From: Erika Davies
Sent: 15 July 2021 16:52
To: ENC PLANNING
Subject: FW: Planning Application NE/21/01069/FUL
Attachments: (00)001 Location and Block Plan Rev A.pdf; (08)003 Proposed Plans and Elevations Rev B.pdf

From: Erika Davies <[REDACTED]>
Sent: 15 July 2021 16:04
To: Jacob Frost <[REDACTED]>
Cc: ENC PLANNING <PLANNING.ENC@northnorthants.gov.uk>
Subject: FW: Planning Application NE/21/01069/FUL

REF NE/21/01069/FUL Single storey ancillary accommodation to replace existing single garage at Pond Yard 32, Back Lane, Collyweston, Northamptonshire, PE9 3PJ

B	Dimension altered on floor plan	15 Jul '21
A	Dimensions added to existing and proposed plans	15 Jul '21

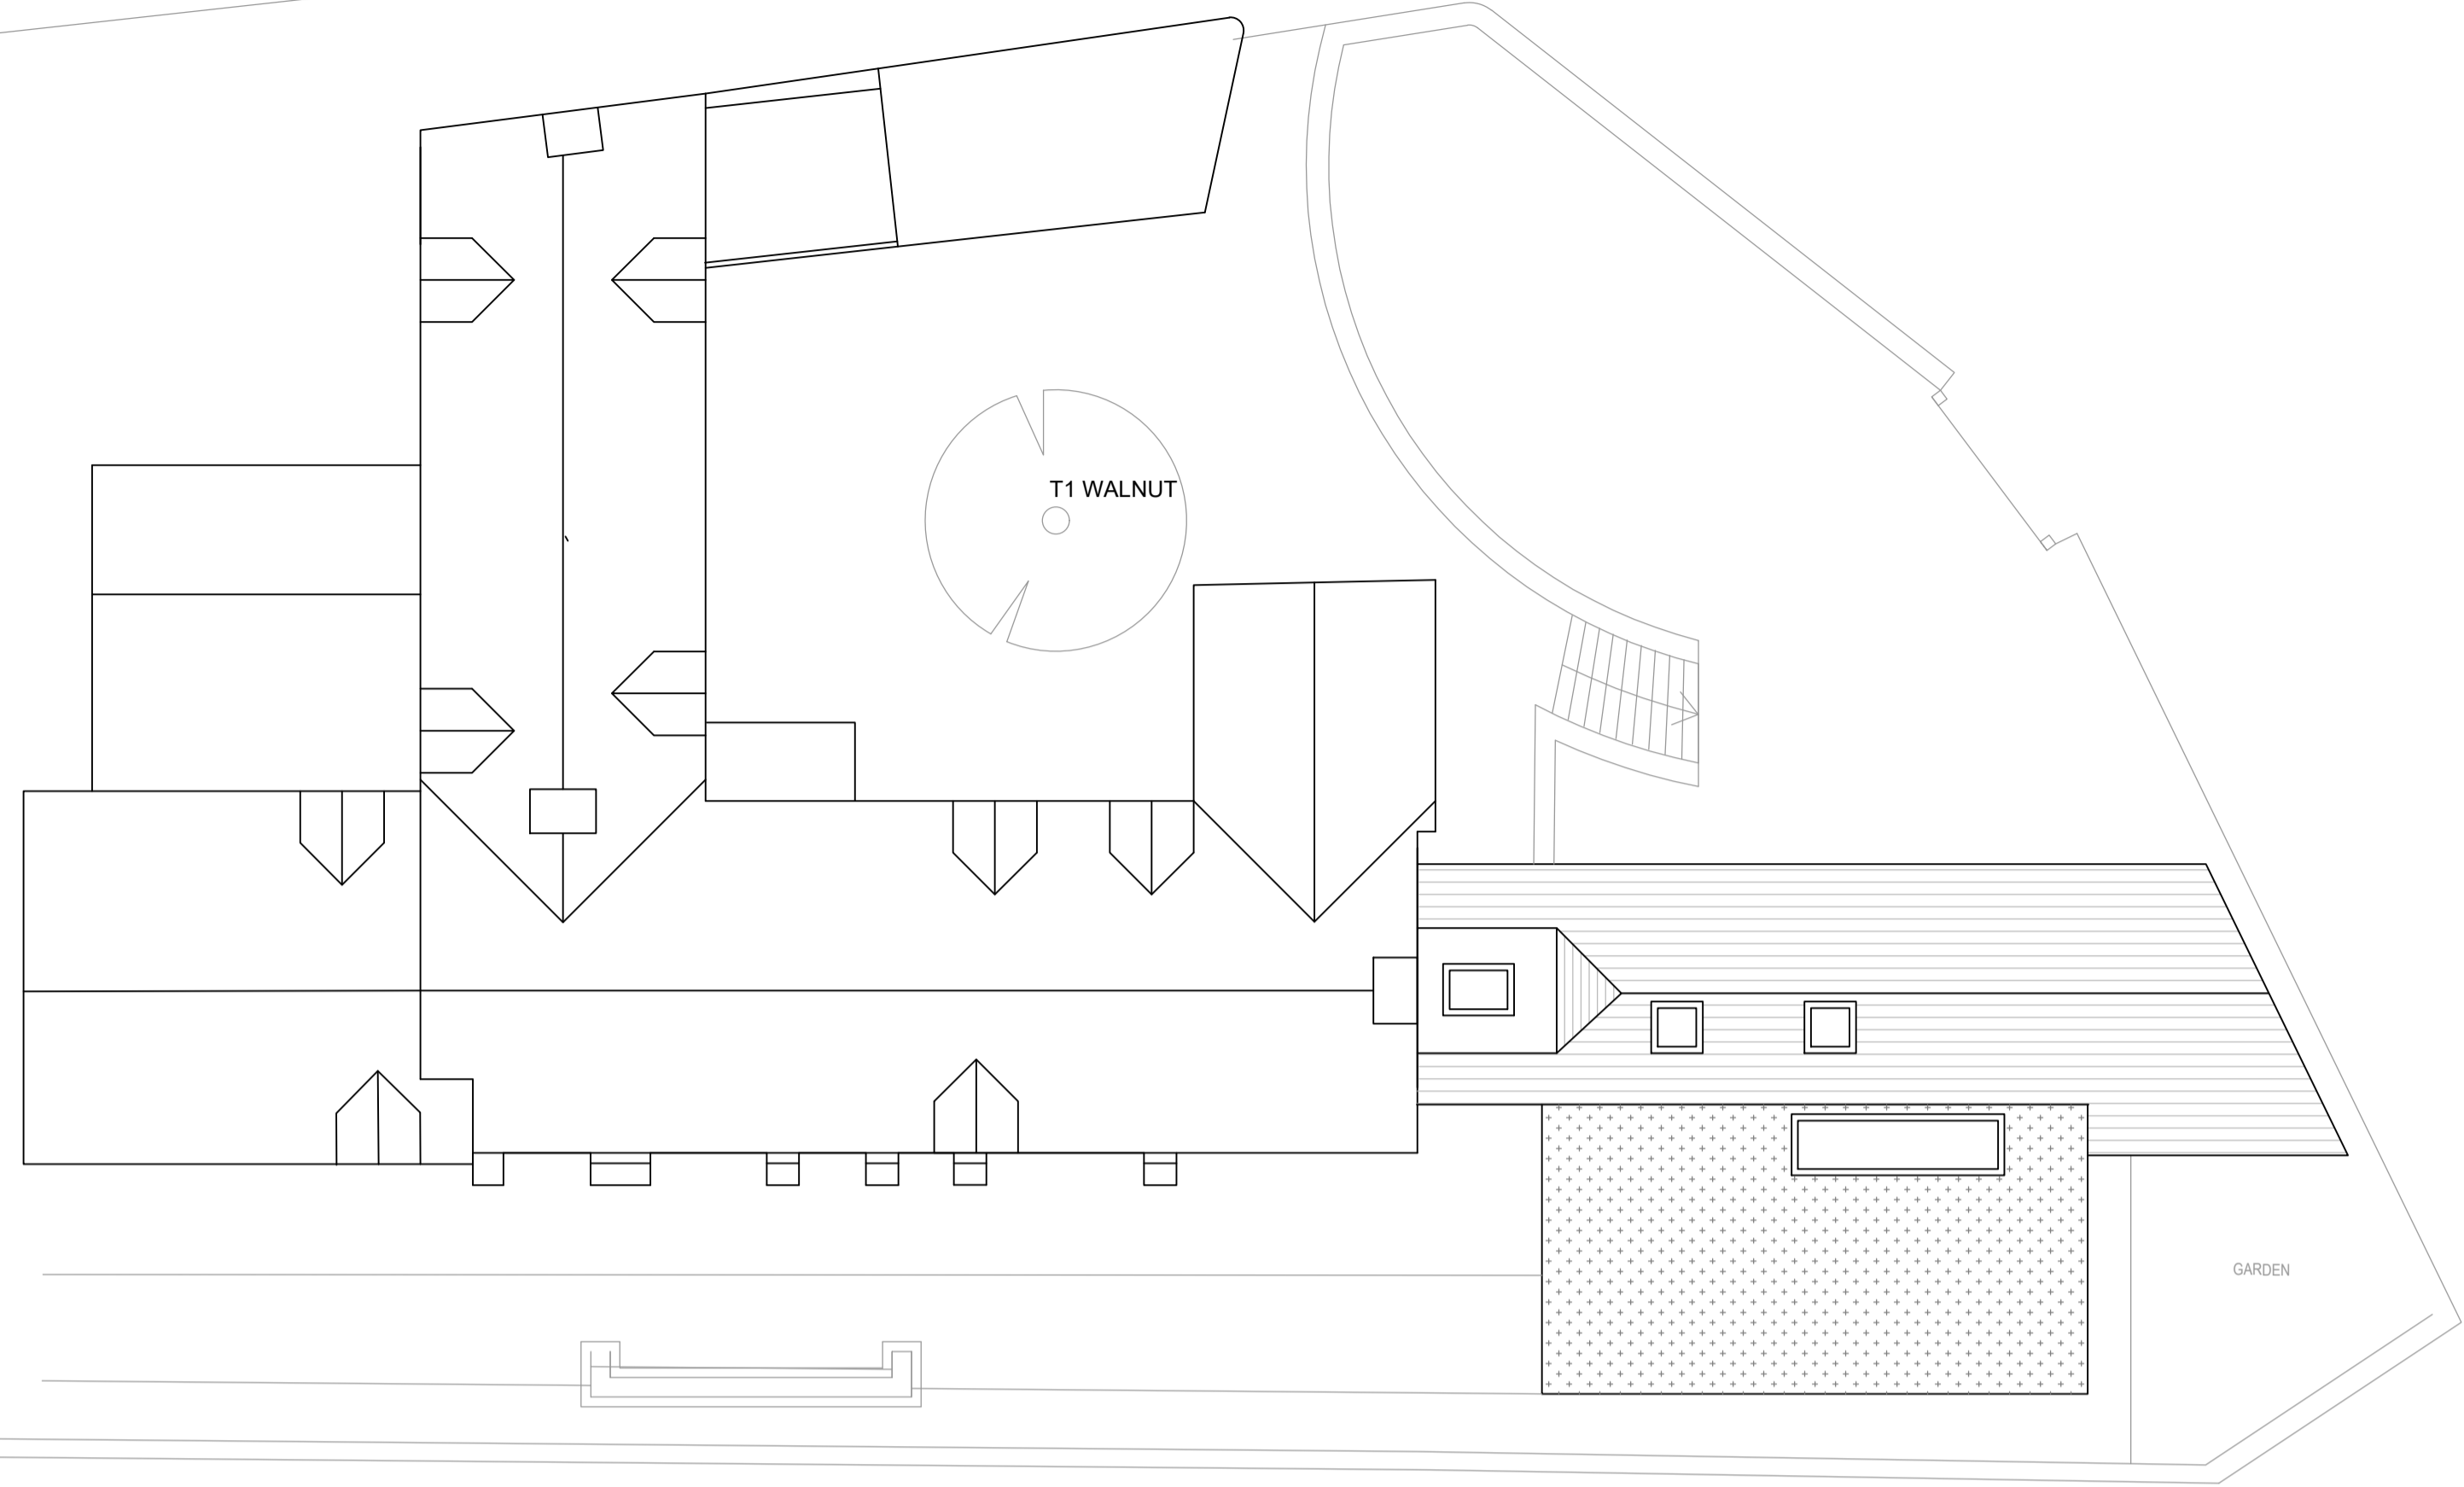
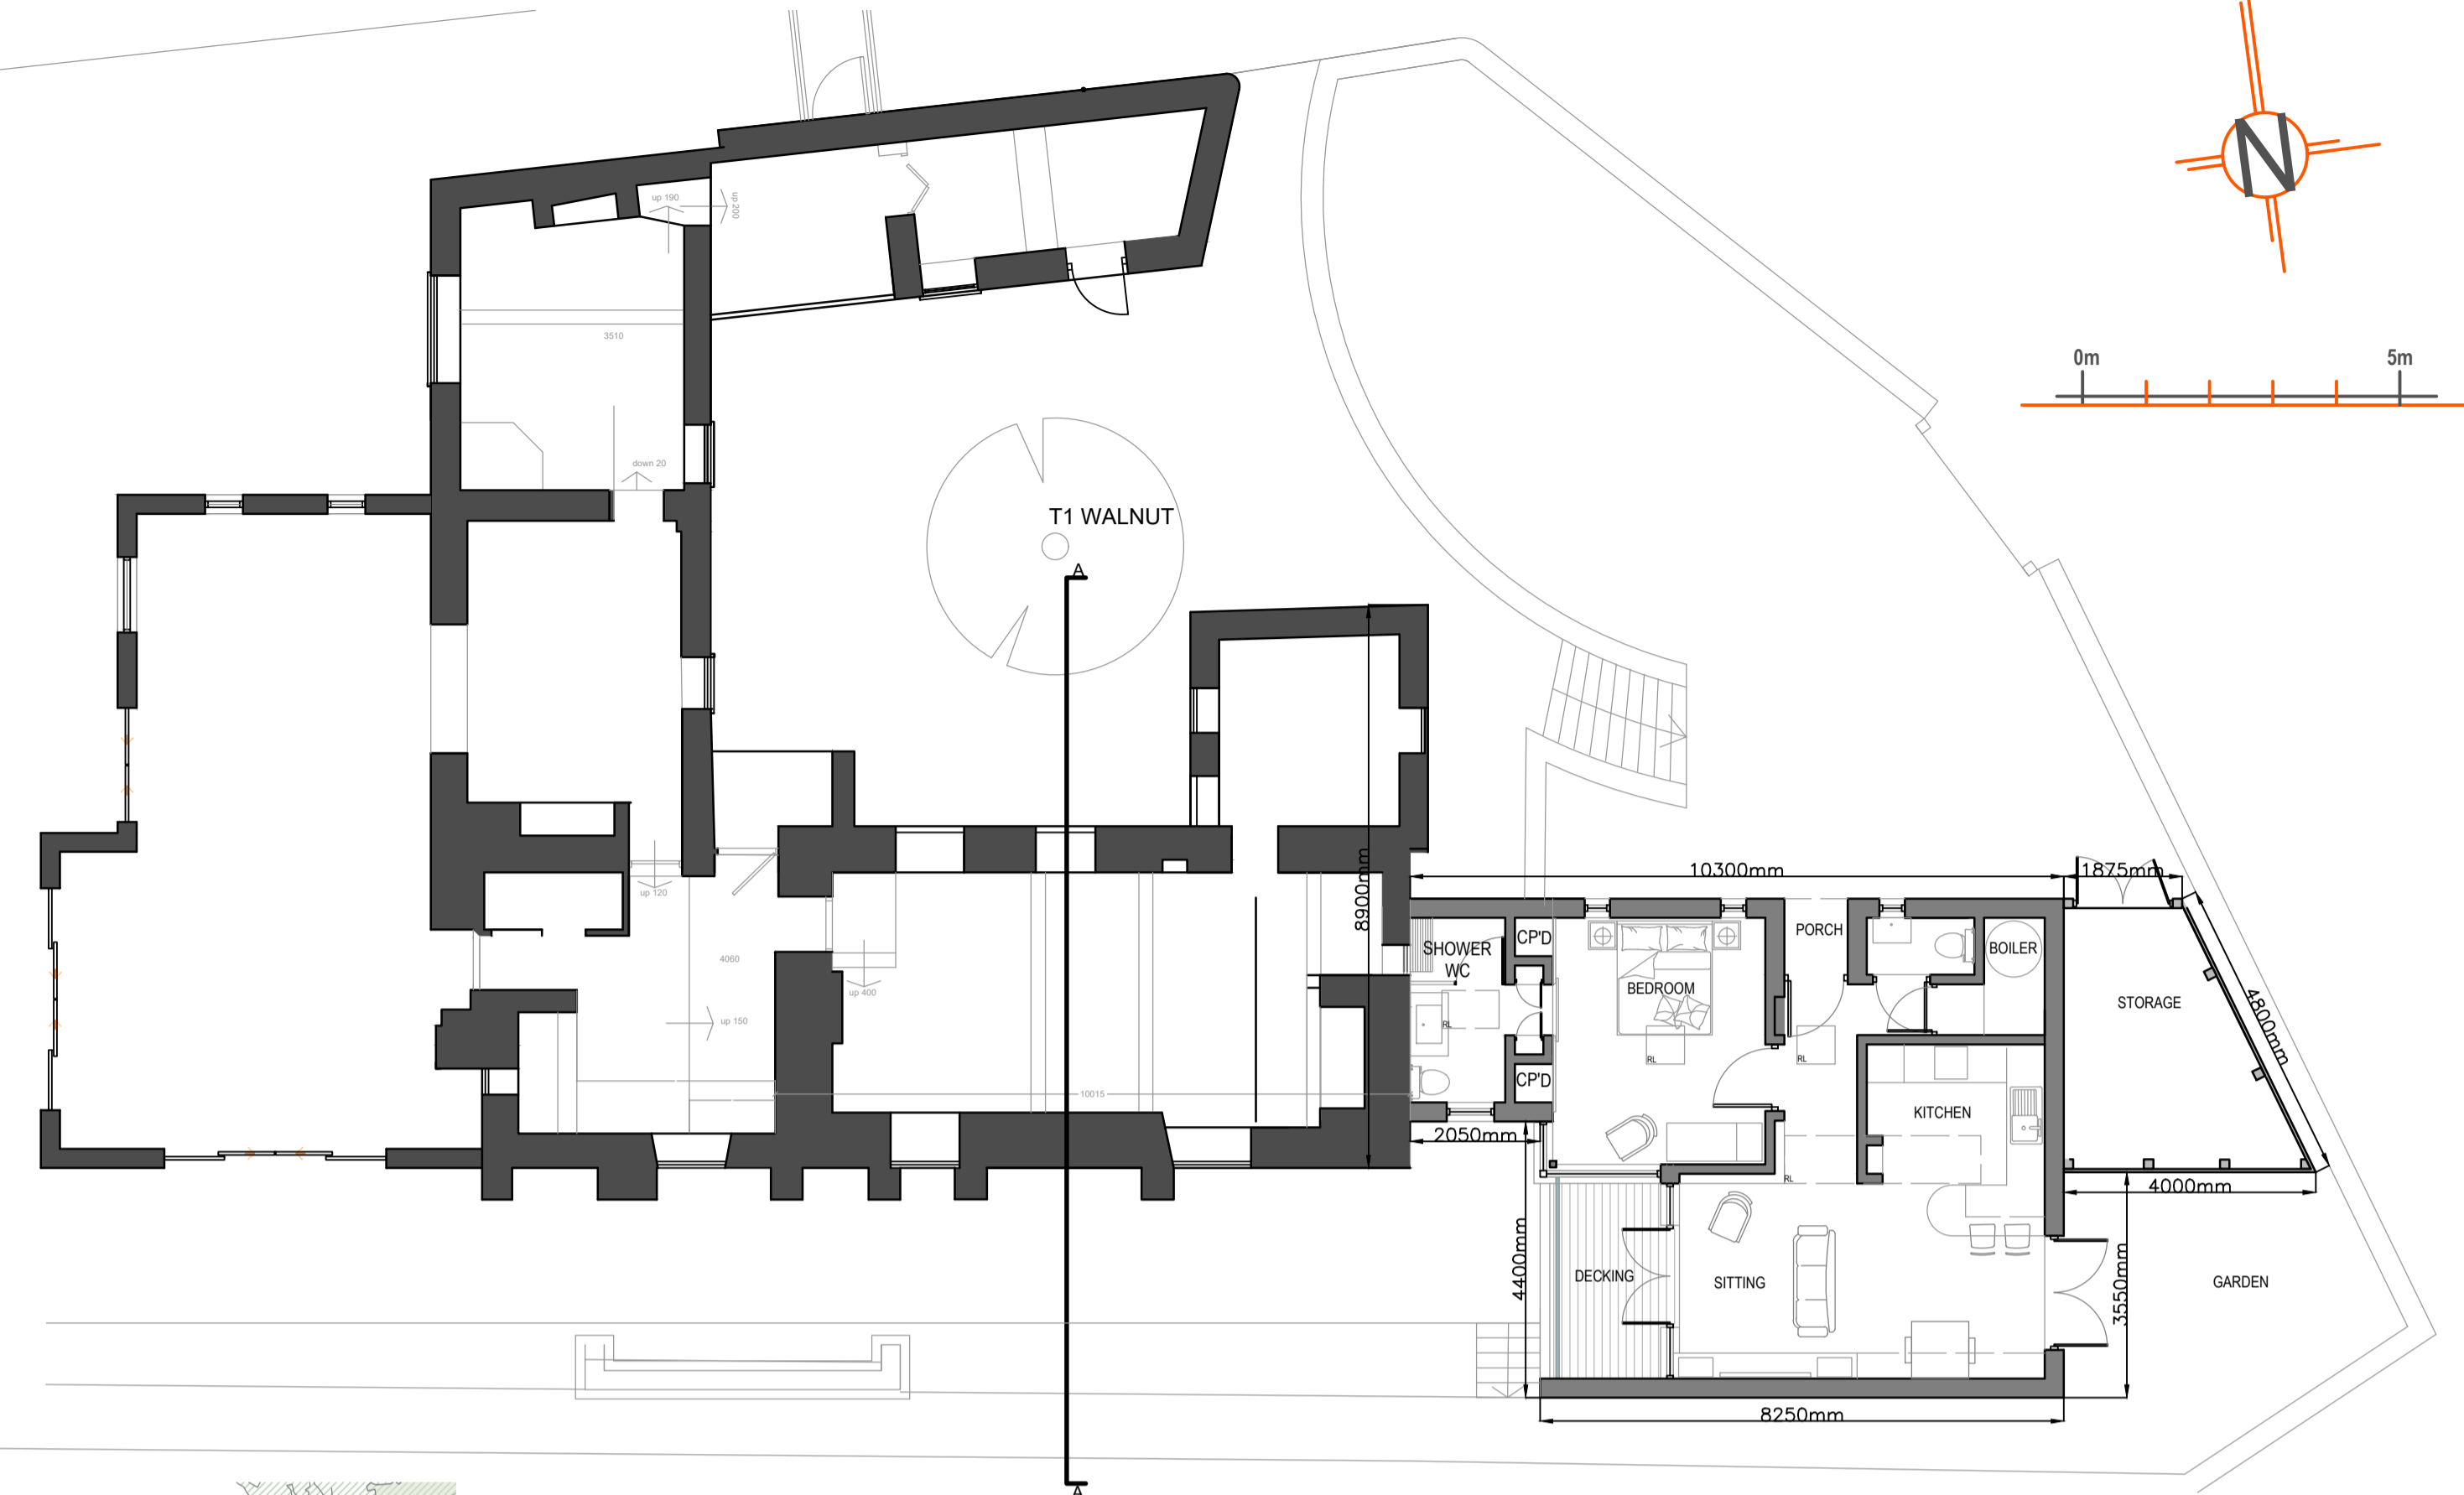
Thank you for the drawings received today, I have accepted the existing floor plans and elevations for validation, I note however that the dimension shown next to the decking on the proposed floor plan as measuring 8900 mm may be incorrect as when measured it comes to just under 4500 mm, this will need to be corrected

I'm just sending over the revised location and proposed floor plan, I hope these are all okay now.
